Re: Town & Country Planning Act 1990

Application ref P/87/11/ - 52 East Front Road Pagham -
Re-submission following application ref:P/47/11

Project	52 EAST FRONT ROAD, PAGHAM, BOGNOR REGIS WEST SUSSEX PO21 4ST	Drawn	sk	Project	126
For	Mr and Mrs Eysers	Scale	1:100 @ A3		
Title	GROUND FLOOR - PROPOSED	Date	25.10.2011	Revision	d
				Drawing No.	P 01

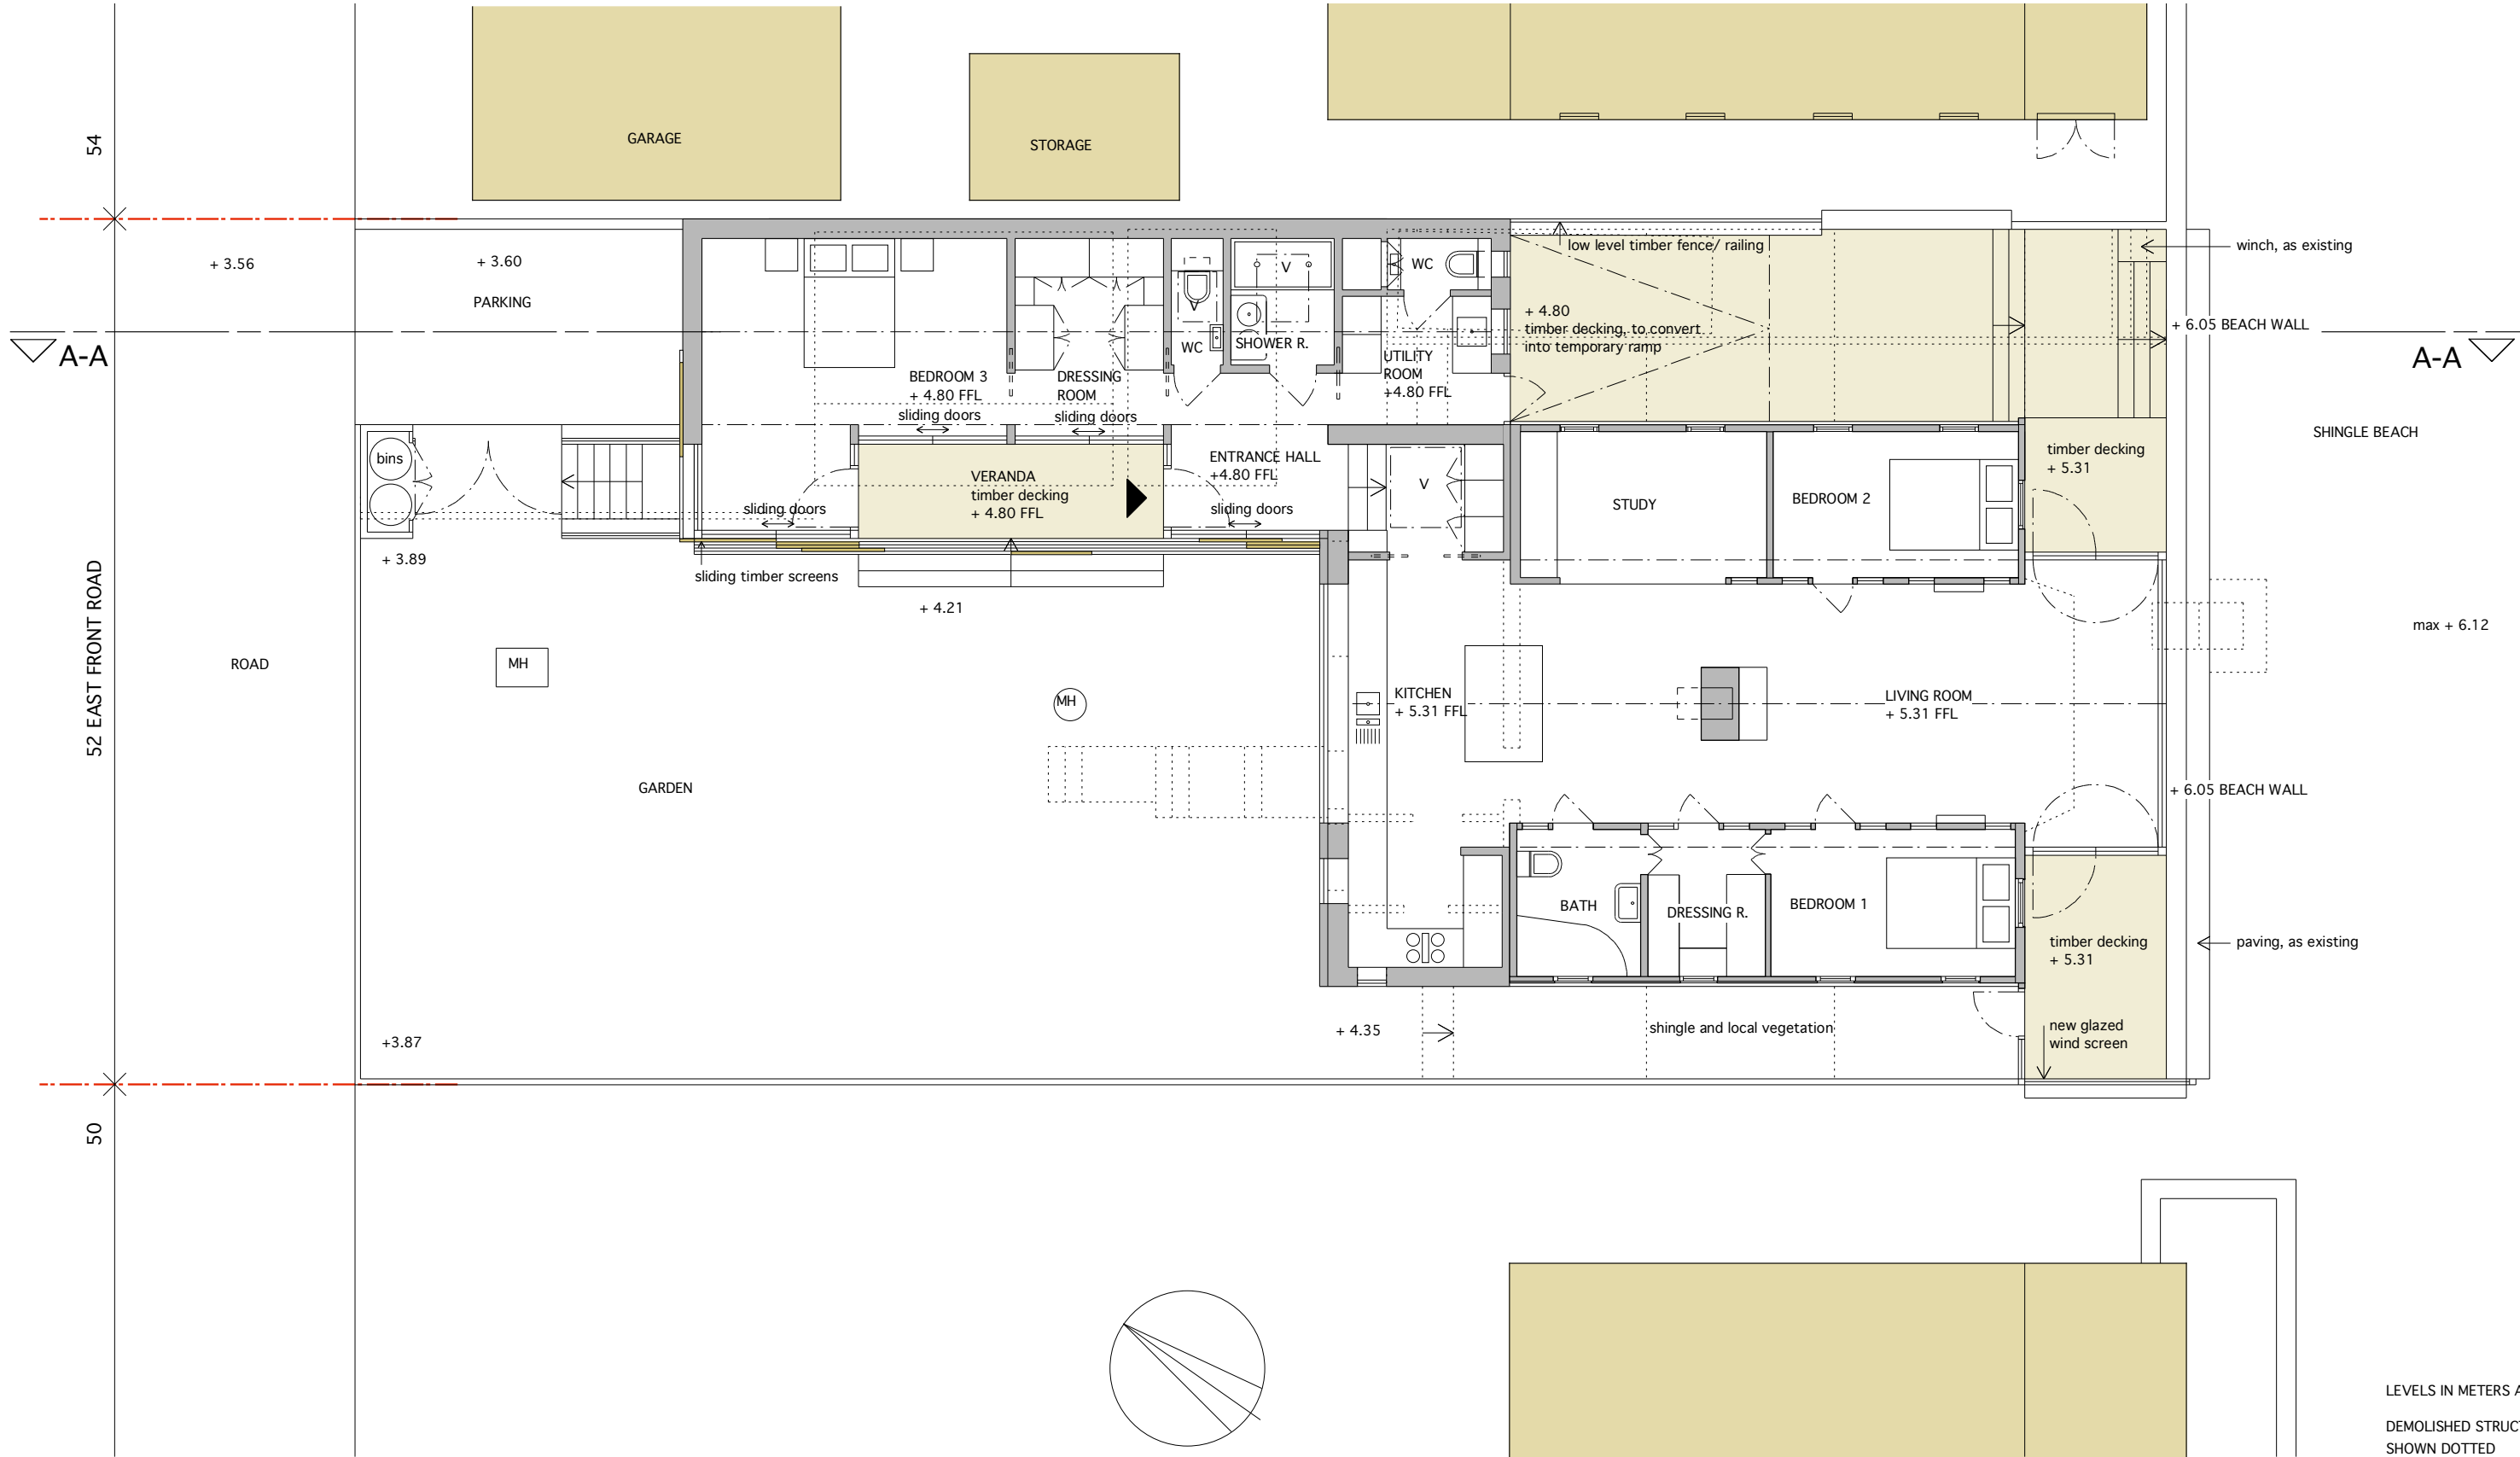
- i) on the east side of no 52 East Front Road you have already granted permission for an extension to be built. This allows the extension to project right to the boundary of our property. This alone will severely restrict the drainage capability along the East flank. This problem is compounded by the fact that you have also granted permission for an extension to the south of the property which removes any chance of drainage towards the west of the property. The only drainage possible after construction will therefore be into and through our property which is a wholly unsatisfactory state of affairs and frankly is totally unacceptable. When the sea over-tops again like it did in recent years, these permitted extensions will act as dams and actually prevent drainage of excess water. This is contrary to Arun Development Criteria which states "Avoid elements which might inhibit free drainage within identified flood risk zone".

- iii) Rainwater gutters and downpipes. None are shown on the plans but no overhang of our vertical boundary of any part of the building or finishes would be acceptable.
- iv) Part of the proposal involves a party wall. No approach has been made to us regarding the necessary handling of this legal matter. Until such legal matters have been notified we cannot agree to any activity

Please also note that on the current application all the existing structures not attached to the main bungalow are drawn and labelled as "boathouse", "store" and "bedroom 3" but are wooden garden sheds and never had any planning permission.

Project	52 EAST FRONT ROAD, PAGHAM, BOGNOR REGIS WEST SUSSEX PO21 4ST	Drawn	sk	Project	126
For	Mr and Mrs Eysers	Scale	1:100 @ A3		
Title	EAST ELEVATION AND SECTION A-A - PROPOSED	Date	25.10.2011	Revision	d
					Drawing No. P 07

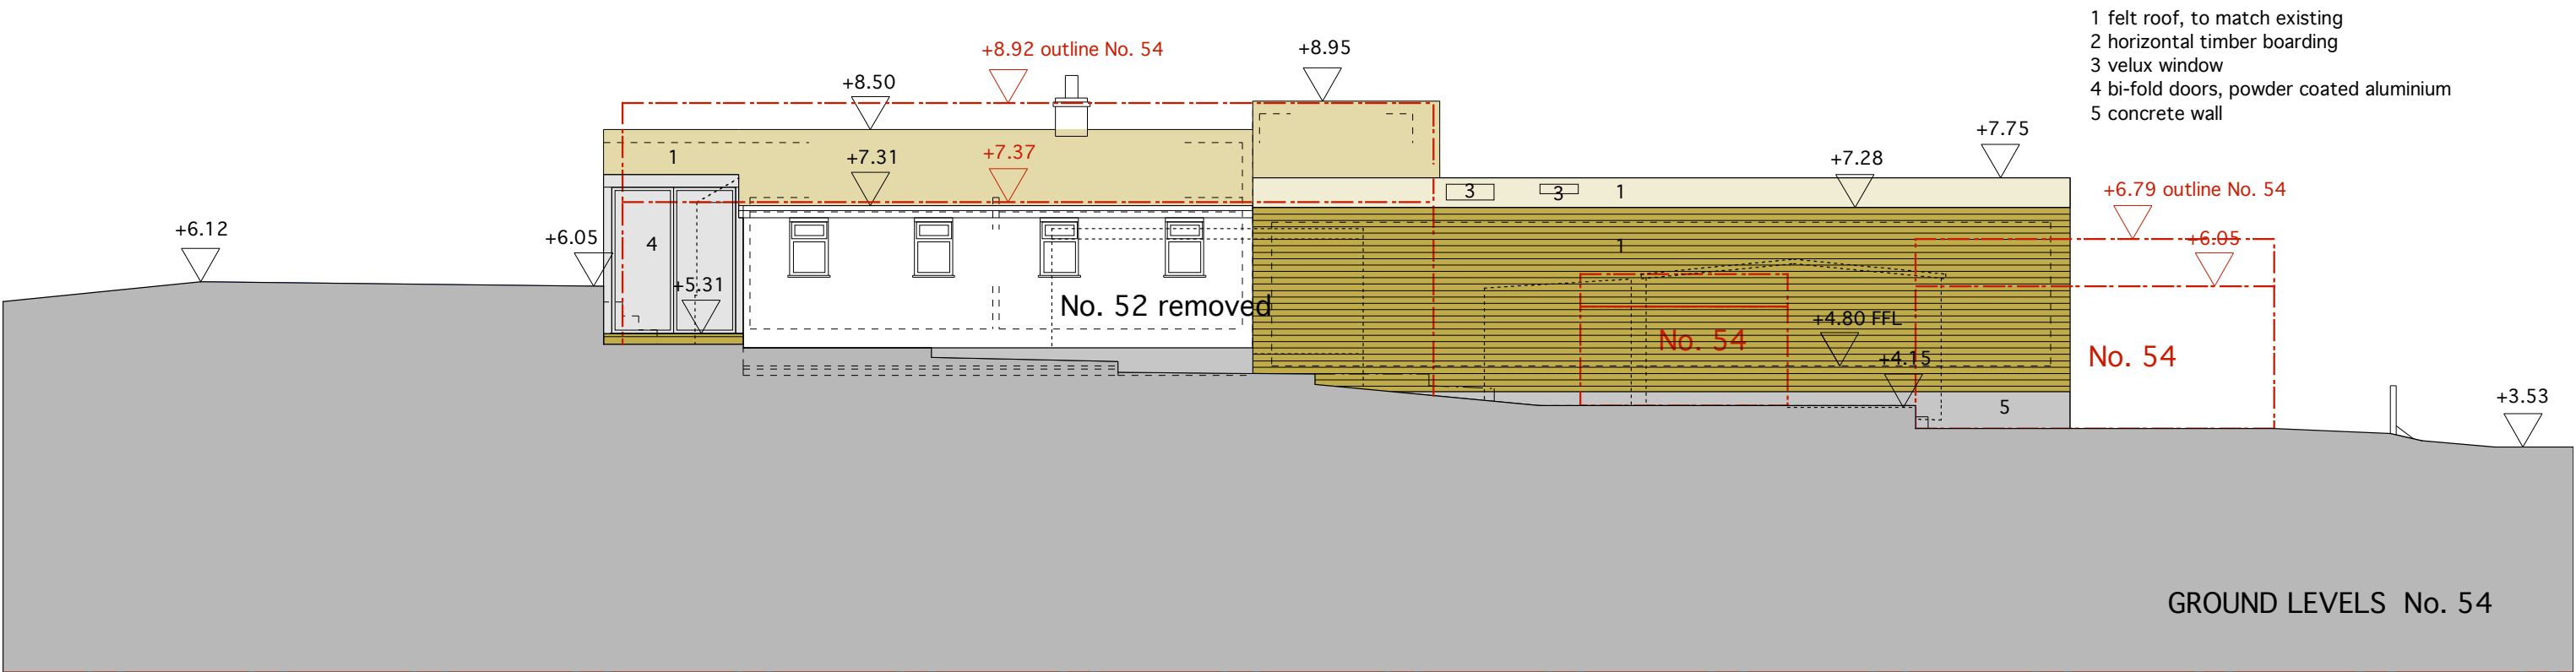
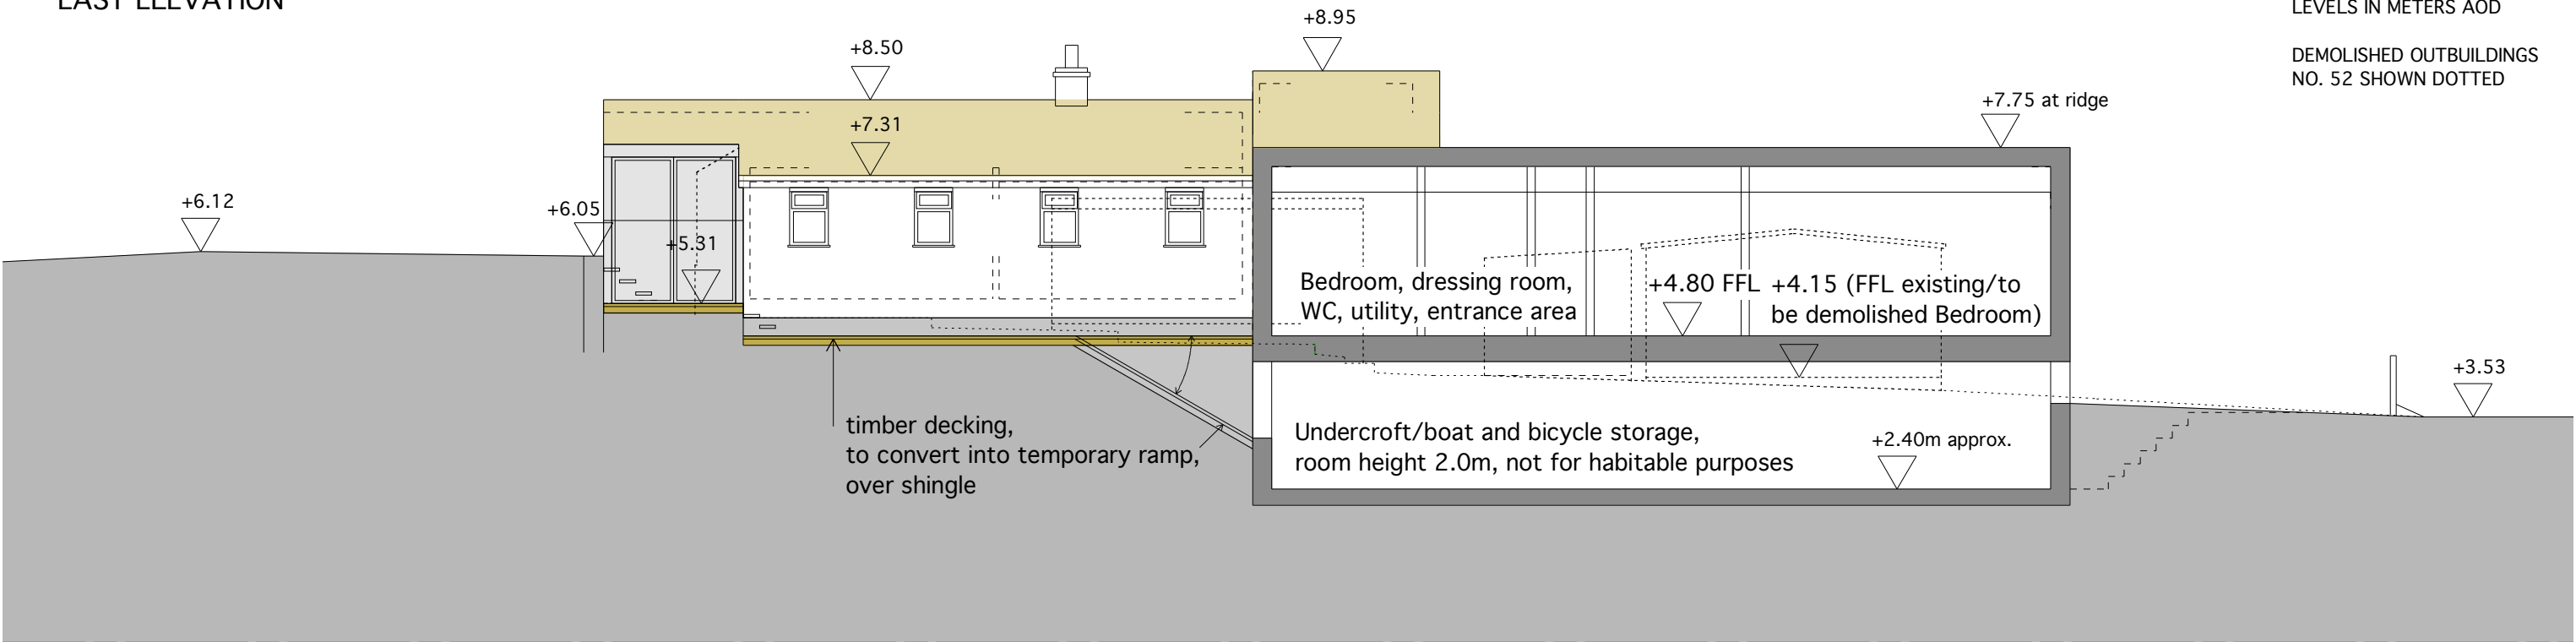
- ii) The proposer is now attempting to expand by stealth, adding extra elements i.e. an undercroft - they call it an "undercroft" which, when included as part of the complete submission P47/11, failed to gain consent. The word "undercroft" is a misleading euphemism for "large subterranean crypt". I feel it may one day prove aptly named if the children are down there when there is heavy rain or overtopping of the sea as mentioned above. In any event it will fill with water which makes it a danger to curious children or pets. We object to any such preposterous innovation right on our boundary. The danger to our structure in constructing such a fiasco is nothing compared to the

The Underground room has by "stealth" found its way back to this application. Our objections on this matter are many. Collateral damage caused by an excavation of gargantuan magnitude is unavoidable to our structure which has remained intact since 1923 - coming up to its centenary year soon. Excavation and piling (ramming sheet metal to a depth of 5 metres (16ft 5" at least) for foundations The beach disruption would cause enormous devastation to the flora and fauna that form the ecology of this last wild and natural environment and shows callous contempt for all our local efforts over many years to protect and nurture this microcosm.

The owners propose to build ON THE BOUNDARY which is 166cm from our toilet/bathroom and bedroom on the west side of our property. This is too close for decent privacy and comfort. At the moment they too have a 160cm wide approx pathway at the side of their property leaving a total space between opposite windows of only 333cm. This hitherto mandatory distance has proved acceptable for all in the years since the properties were built in 1920-1925. It will be reduced to 160cm i.e. only 5ft 5inches in total at the widest part reducing to a gap of only 5ft 3" between opposing buildings (except where the extension projects to the boundary).

The bulk of the proposal right on the boundary effectively eliminates our view to the west with its trees and hedgerow down to Pagham parade and all the SSSI to the west of us, in breach of Policy Gen.7v and Gen7vi). We will be staring at a blank wall towering above our own fence and obscuring a large
